RE: Master Drainage Report for Westpoint 40
Drainage Master Plan
Stamp Date: 8/25/17
Hydrology File: K09D041

Based upon the information provided in your submittal received 8/25/17, the Drainage Master Plan **is not** approved for Work Order. The following comments need to be addressed for approval of the above referenced project:

MASTER DRAINAGE REPORT FOR WESTPOINT 40 (AVALON SUBDIVISION UNIT 5)

**EXHIBIT 2 – EXISTING CONDITIONS
DRAINAGE MAP**

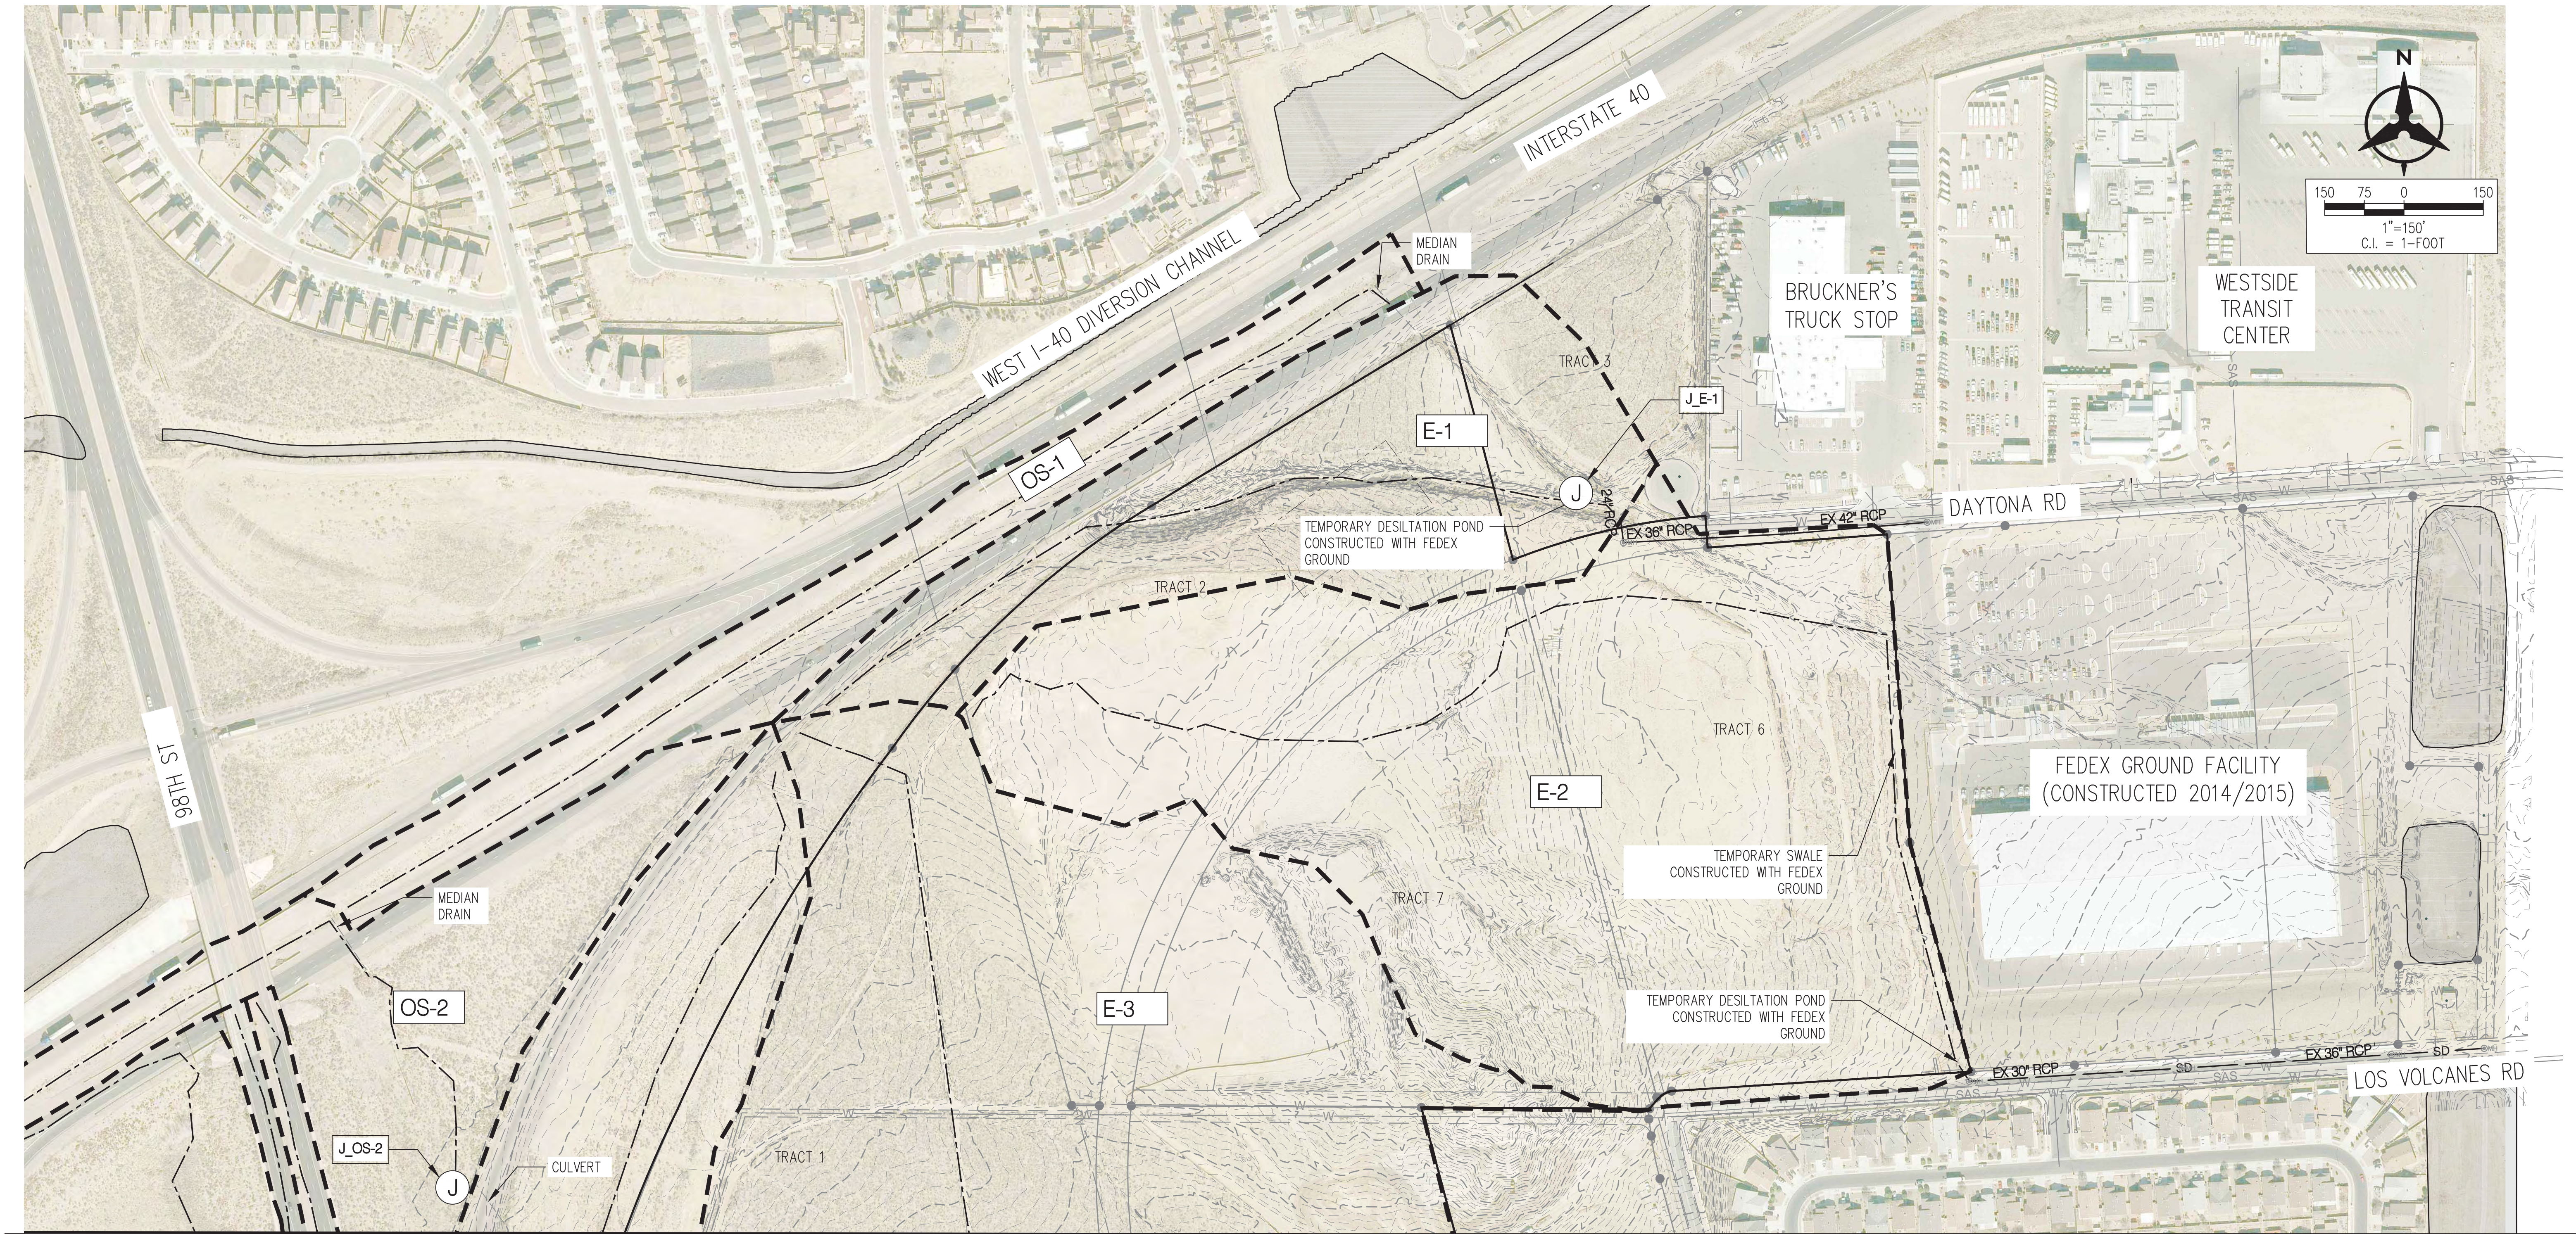
1. On your existing model, Point J_OS6 needs to be routed through a reach to J_E-4. This existing drainage channel can be seen on the aerial.
